Engineers Comments Regarding Condition 10

Application No: BN/134/21/DOC
Registered: 13th October 2021
Site Address: Land rear of 1 Northfields Cottage Fontwell Avenue Eastergate PO20 3RX
Grid Reference: 494746 106250
Category: Discharge of Condi
Description of Works: Approval of details reserved by condition imposed under BN/50/20/PL relating to conditions 10-surface water drainage, 11-maintenance & management of surface water drainage & 20-materials & finishes.

Checked By RW	Checked Date 21.04.21	Drawn By RD	Drawn Date 20.04.21
Client Drawing No.		Scale 1:20	(AT A1 SIZE)
PBA Drawing No. 108.5009.551			Revision F

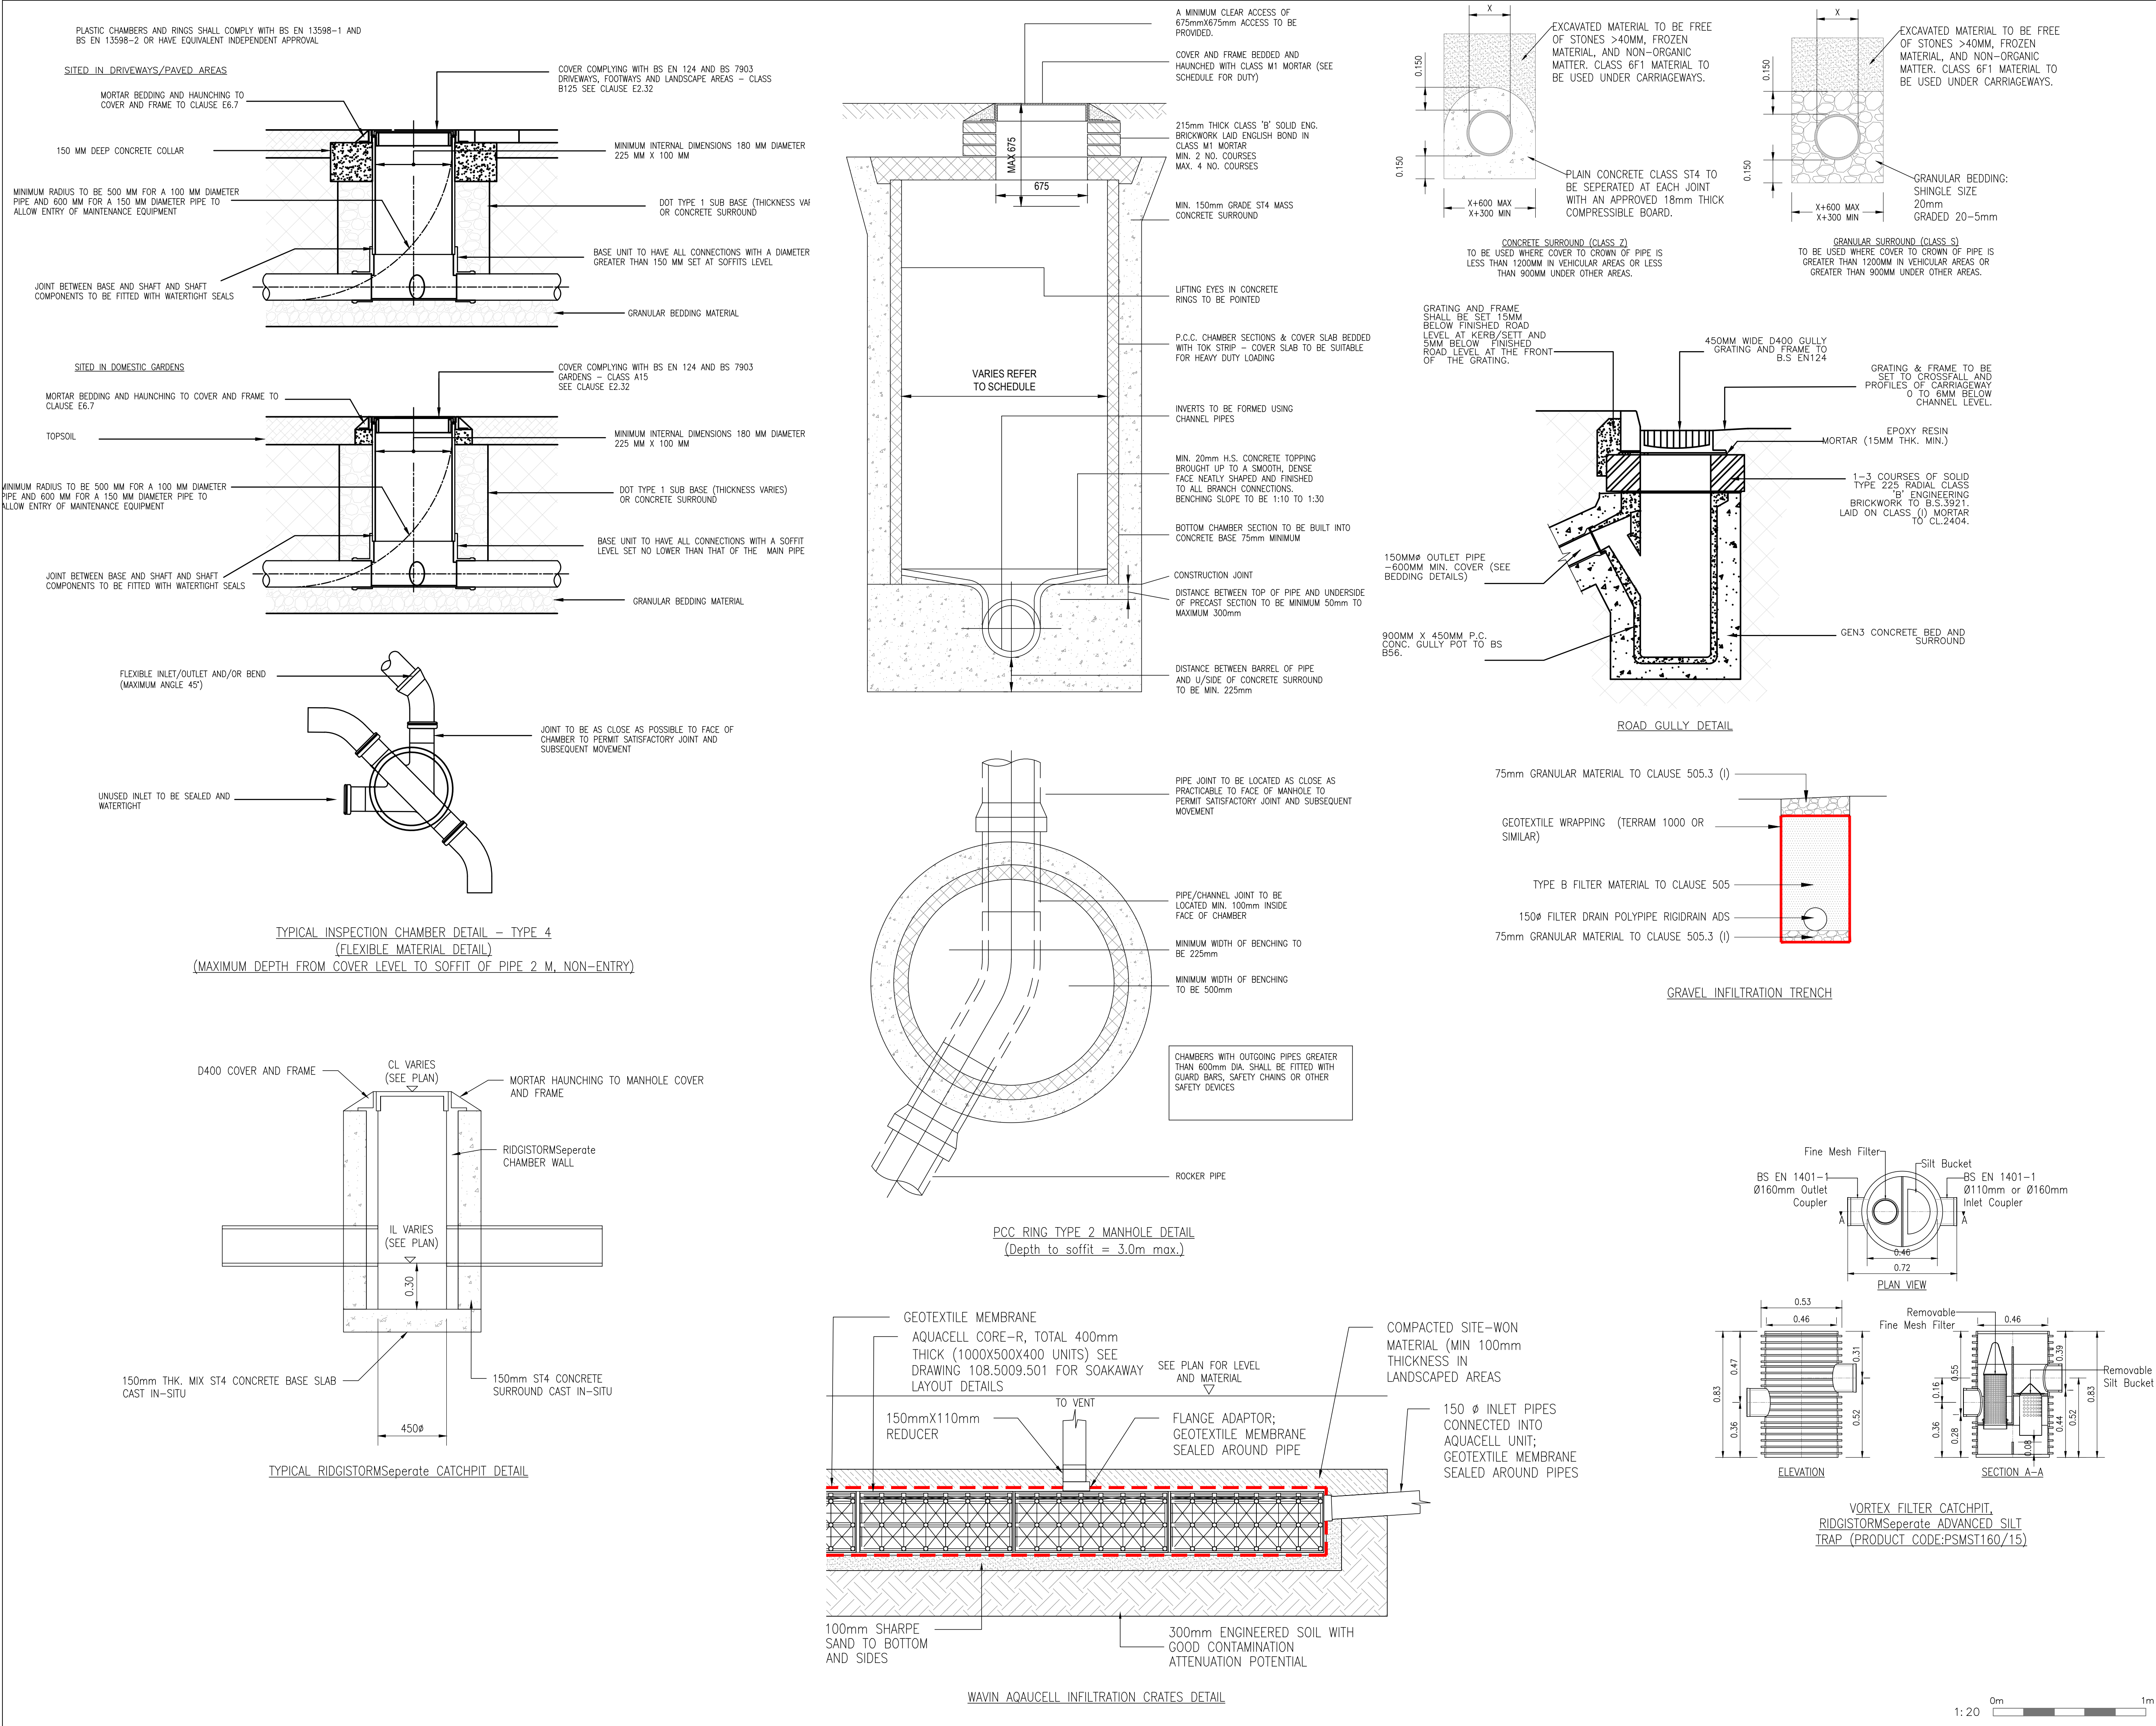
1. Revised calculation printouts for all features do not appear to have been supplied. This is required to show what impermeable area has been inputted into calculations. (As per previous point 3).
2. Revised calculations results for the soakaway for plot 4 have not been supplied. (As per previous point 4)
3. An updated drawing of 551 has not been supplied with this latest information. This is required to demonstrate requested amendments have been made to the soakaway construction detail drawing. (As per previous points 8 and 9)
